Planning Application Reference: AW/159/13 (78 Barrack Lane)

We wish to advise you of our opposition to the above application for planning approval for the following reasons:-

Drawing No:
02

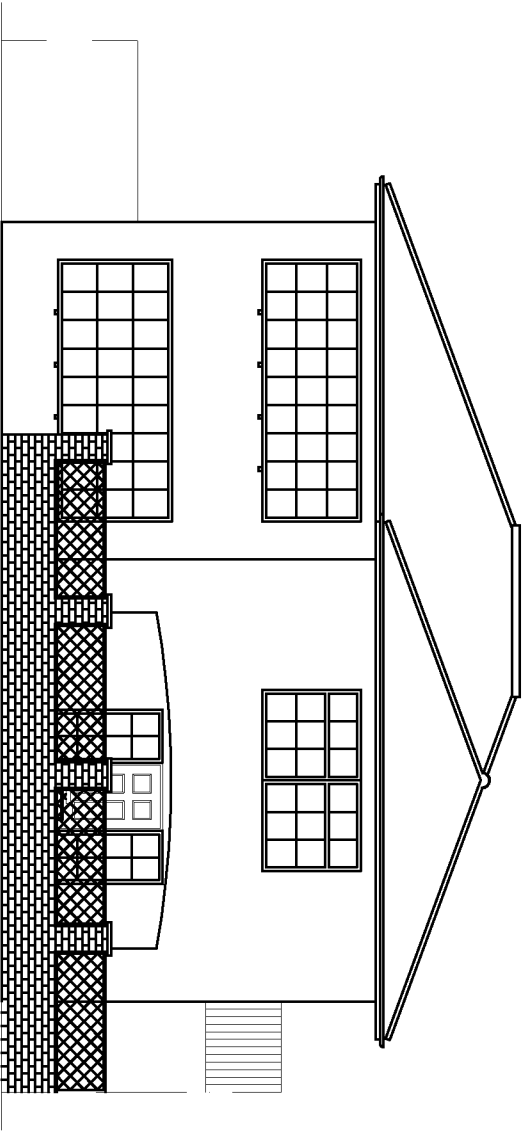
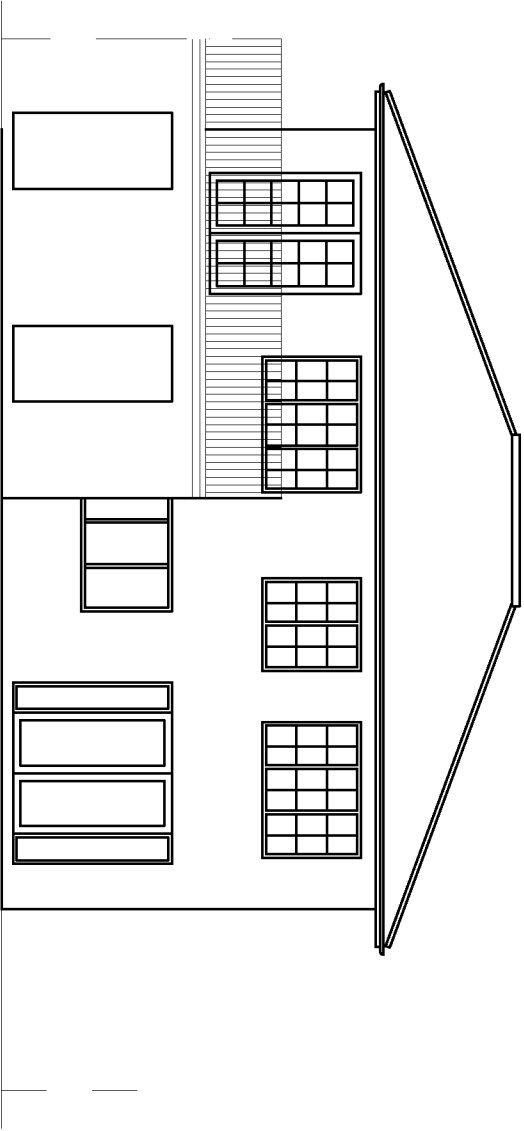
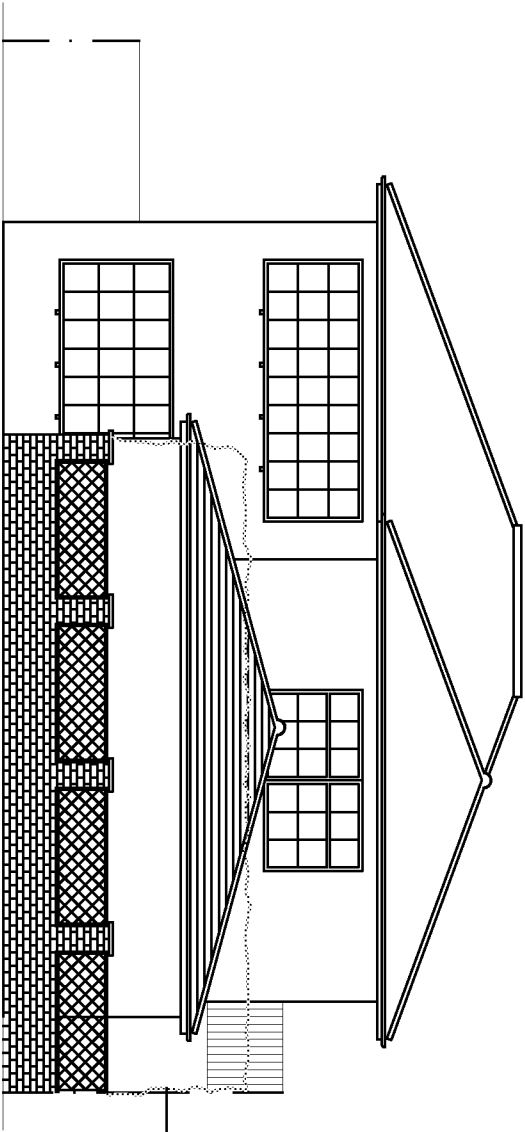
1. The foundations will cover and probably damage the roots of a tree, which we understand is the subject of a Tree Preservation Order; it is shown on the architects drawing number 02. The tree is in the south east corner of the neighbouring garden, number 76 Barrack Lane.
2. This would be a massive structure both in floor area and height, taking over a large percentage of the front garden. The roof line would visually cut into the upper windows of the existing house.
3. It would be, we believe, the only house in Barrack lane to broach the 'Building Line'.
4. The appearance would not be sympathetic to this area of Special Character.
5. The open view, which we currently enjoy, of Barrack Lane trees and hedges, would be severely blocked.
